I enclose a chronology of documents and events relating to the conduct of One Earth. I believe it demonstrates that One Earth has deliberately and consistently failed to report to the Inspectorate a legitimate challenge to the validity of the way they were conducting the consultation on their project. They have also deliberately and consistently withheld relevant documents from the Consultation Report and examination with the intention of hiding from the Inspectorate the true nature of the consultation despite the Inspectorate's advice recorded in 3.7.2 of the Consultation Report and [REDACTED]

Flood Risk and Runoff Impacts of Large Solar Farms Including Cumulative Effects

The One Earth Solar proposal should not be approved, as the proposal is to build on a flood plain and the flood risk assessment fails to demonstrate that there will be no rise in flood risk either locally or elsewhere, nor does it provide assurances regarding the safety of the project itself.

Outline Surface Water Drainage Strategy Plans

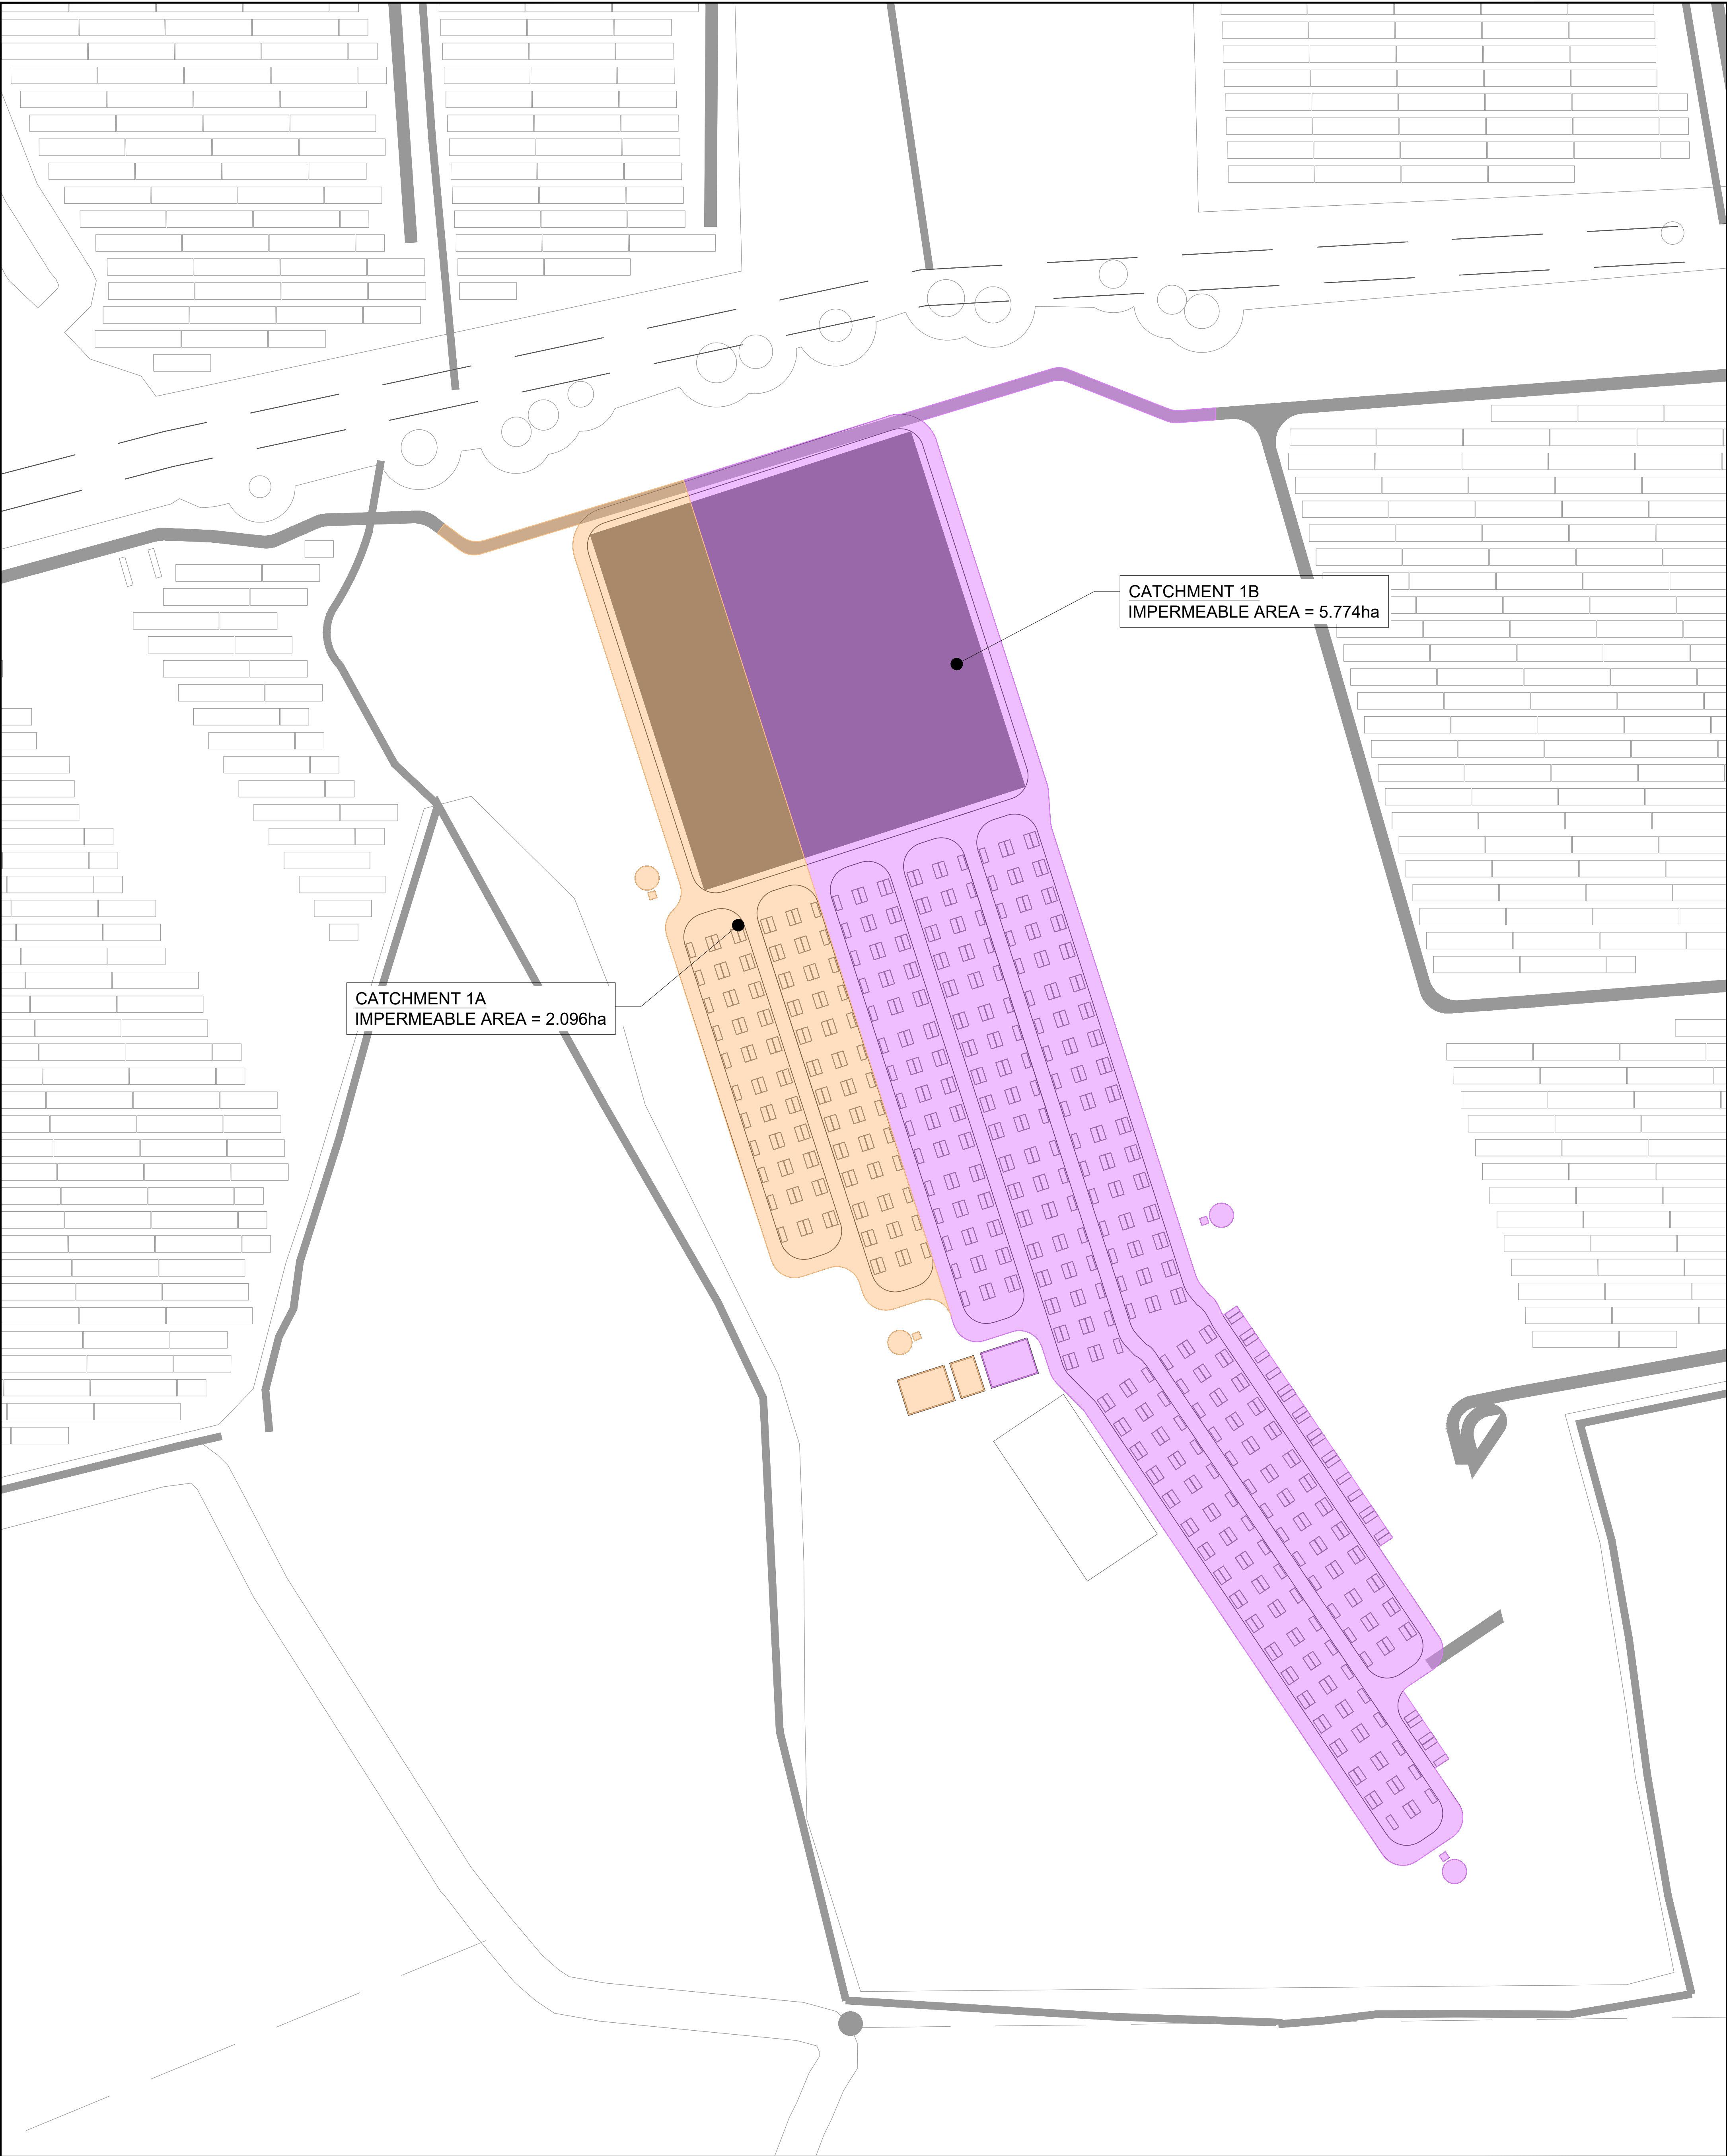
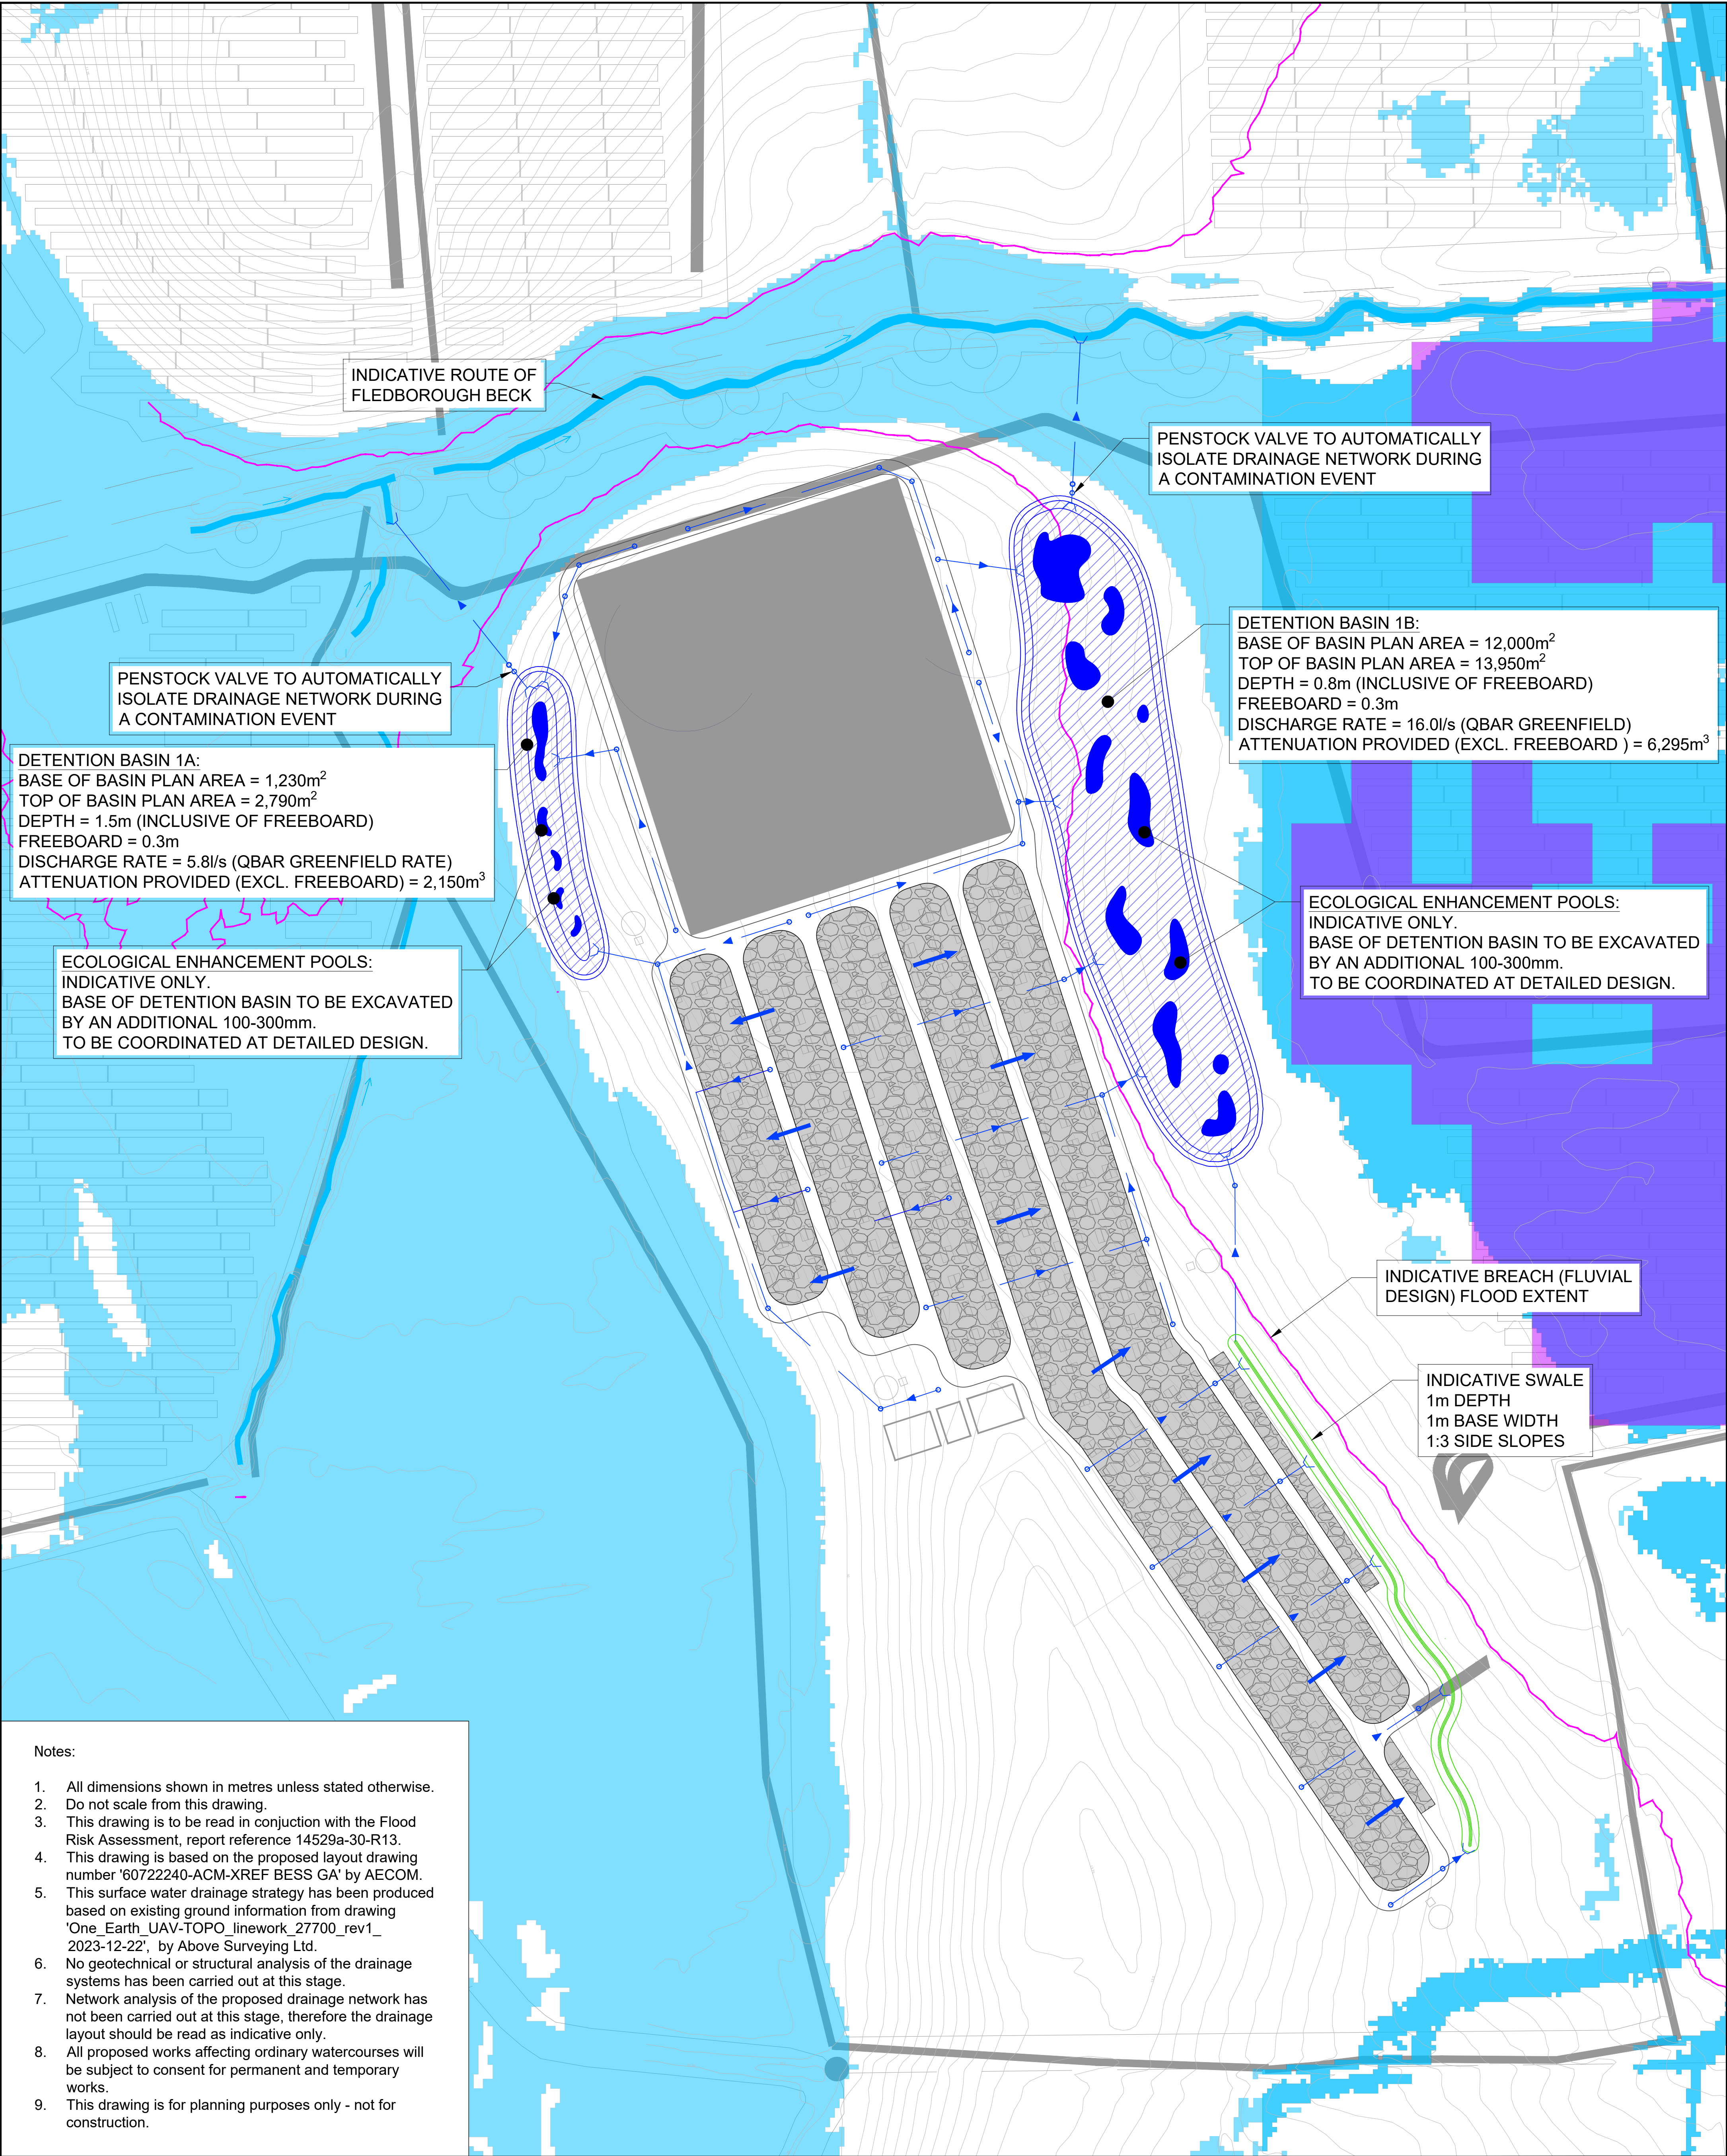
The Wallingford Procedure model used in the flood risk assessment is not designed for solar farms and does not adequately account for solar panel runoff or peak discharge rates.. Therefore, this model is not sufficient for evaluating solar farm flood risks in the absence of empirical evidence to the contrary. Custom modelling and monitoring of similar-sized solar farms outside flood plains are necessary before considering this proposal.

It is critical that there is professional coordinated consultation and planning by the affected drainage authorities and the Environment agency to understand these cumulative effects of, and assess the adequacy of the drainage systems' capability to cope with the combined impact, of multiple solar farms. The first thing to establish would be to be what level of run off, speed of run off and peak discharge rates that existing drainage systems and waterways can cope with. The One Earth FRA does not adequately address this.
